MEMORANDUM

TO: Jean Fraser, Planner
FROM: David Senus, P.E. & Ashley Auger, E.I.T.
DATE: November 20, 2013
RE: Munjoy Heights, Level III Site Plan Application

Woodard & Curran has reviewed the Final Level III Site Plan Application for the proposed infill residential development located at 79 Walnut Street in Portland, Maine. The project consists of the demolition of two structures and the development of 29 townhouse style residences.

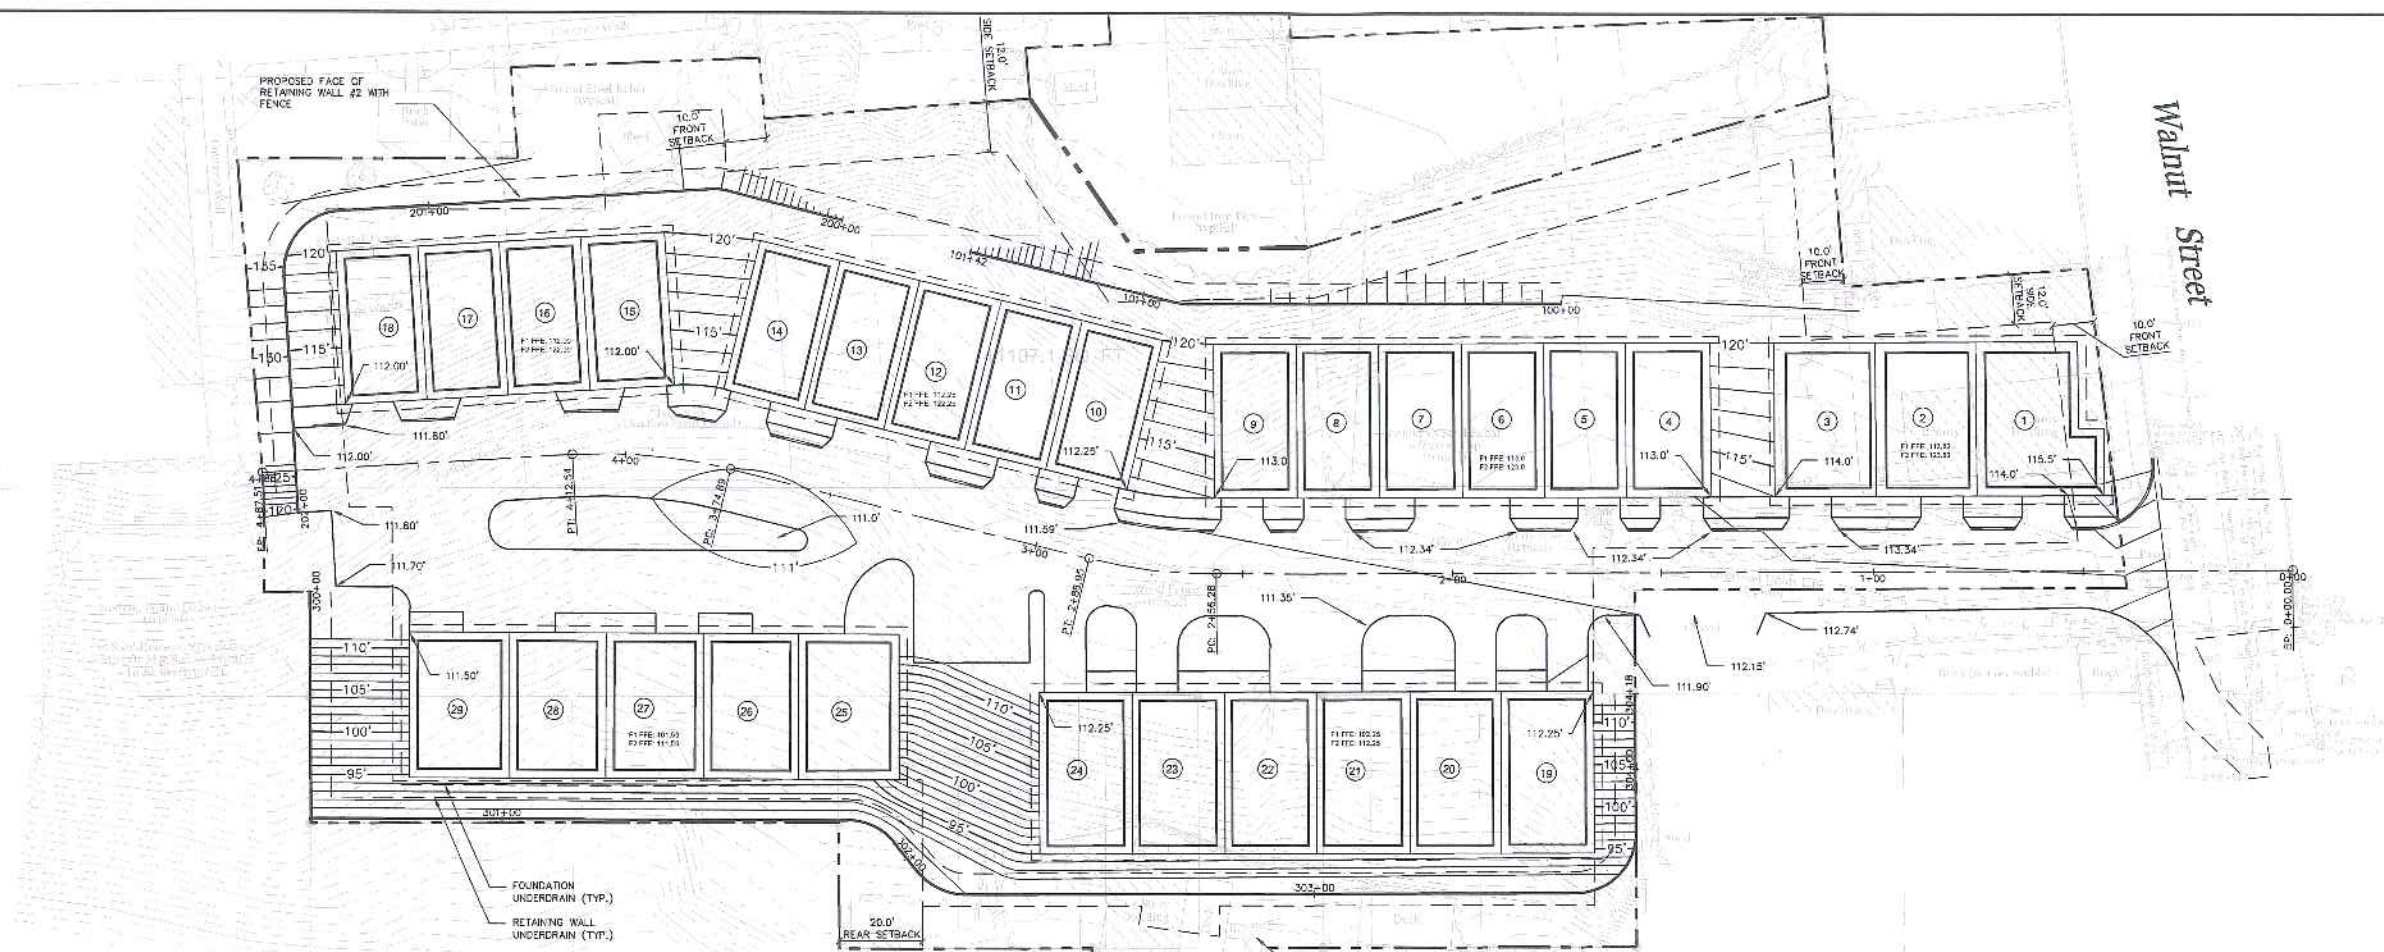
- 22) Sheet C-31, the centerline profile indicates that Existing SMH1 and Existing DMH1 in Walnut street have 2' deep sumps. This would not be a standard condition for City manholes. The applicant should review and revise the plan accordingly.
